From: Bruce Zhang <Bruce.Zhang@planning.nsw.gov.au>
Sent: Thursday, 18 February 2021 1:58 PM
To: Jacqueline Parker
Cc: Russell Hogan; Grace Macdonald; William Hodgkinson
Subject: FW: Aspect Industrial Estate (SSD 10448) - NRAR riparian advice

From: Jane Curran <jane.curran@nrar.nsw.gov.au>
Sent: Friday, 12 February 2021 14:18
To: Bruce Zhang <Bruce.Zhang@planning.nsw.gov.au>
Subject: Aspect Industrial Estate (SSD 10448) - NRAR riparian advice

You have requested NRAR provide some advice around the proposed watercourse realignments at the Mamre Road Precinct, namely the SSD relating to the Aspect Industrial Estate (SSD 10448) development proposal. NRAR have provided advice in relation to the water licencing component of the development and now provides the following advice for the watercourse.

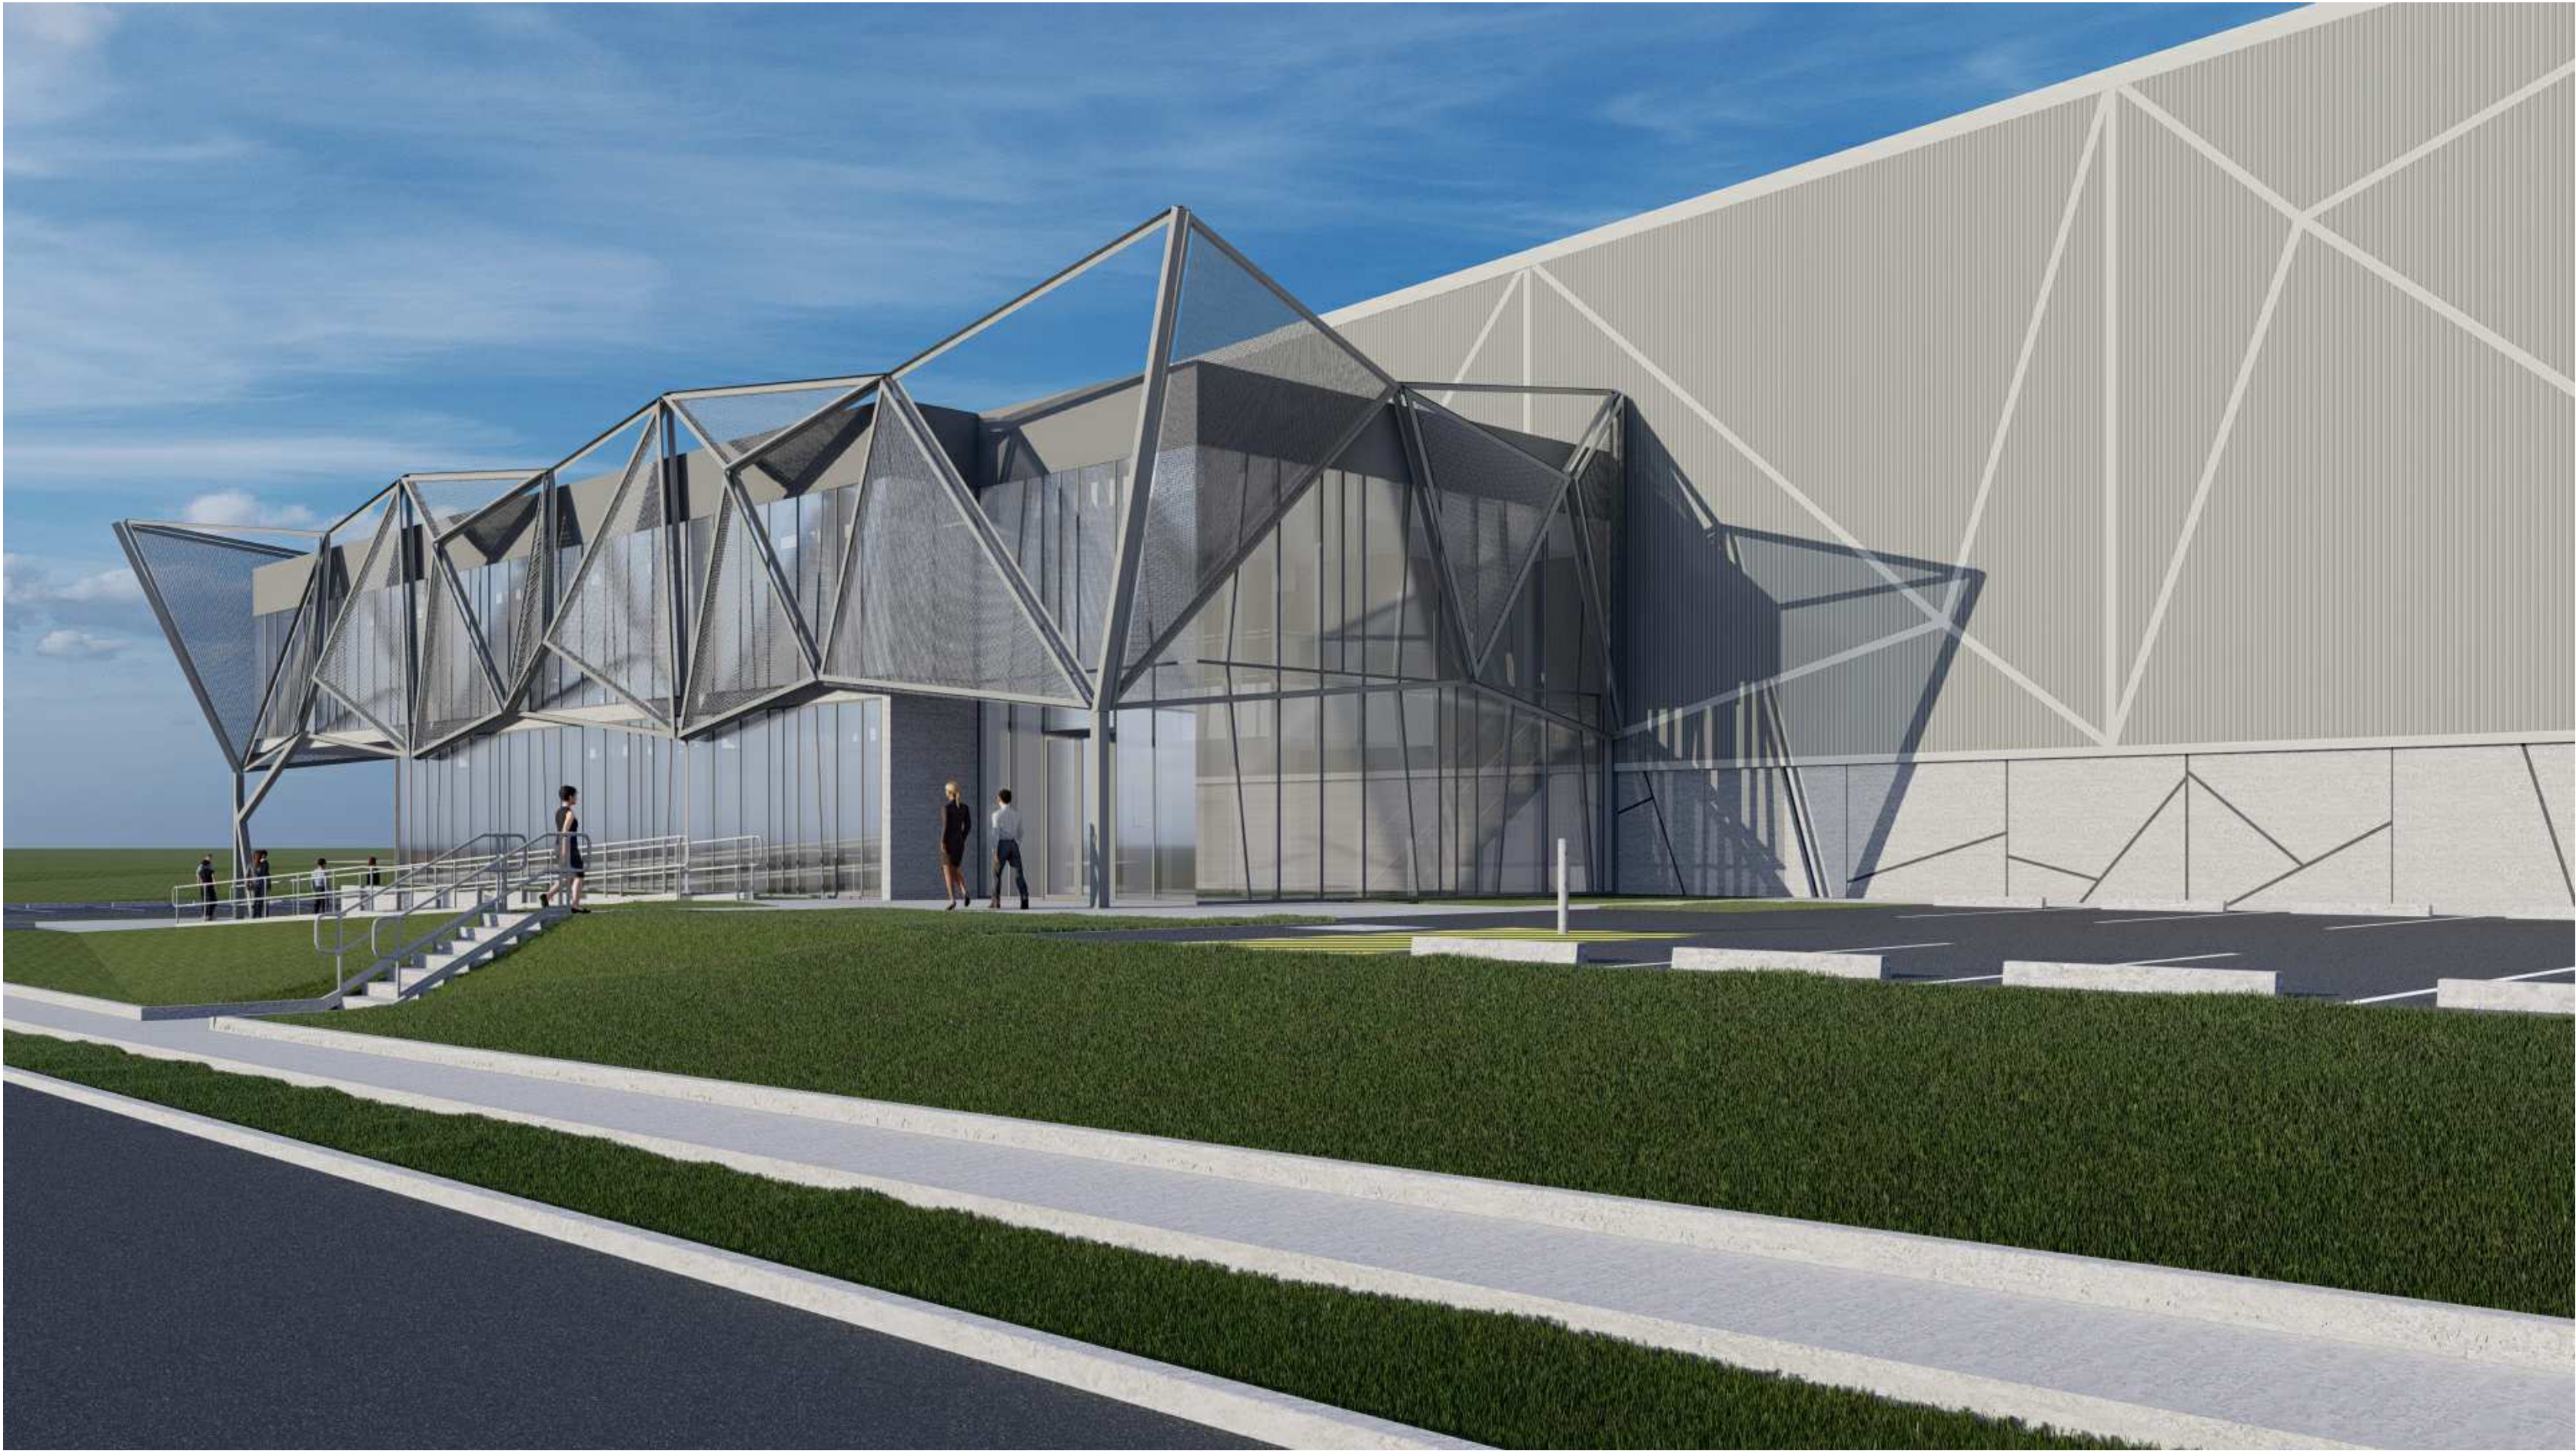
- A 2nd order watercourse is present and will be realigned. In accordance with NRARs Guidelines, 2nd order watercourses require a 20 m Vegetated Riparian Zone (VRZ) measured from top of bank either side of the watercourse. The Vegetation Management Plan (VMP) area and watercourse realignment does not include the required 20 m VRZ but has instead designed the realignment to include a meandering watercourse alignment with various VRZ widths. When the overall VRZ area is combined, the VRZ is approximately equivalent to a 20m VRZ measured from top of bank. This approach is considered acceptable in this instance and will provide good riparian outcomes.

- The proposed realignment is in accordance with the design reviewed during NRARs consultation with the proponent and the proposal is in general accordance with the NRAR Guidelines for Controlled Activities on Waterfront Land found here - https://www.industry.nsw.gov.au/_data/assets/pdf_file/0004/156865/NRAR-Guidelines-for-controlled-activities-on-waterfront-land-Riparian-corridors.pdf

- The proposed realignment is to link to the upstream watercourse alignment.
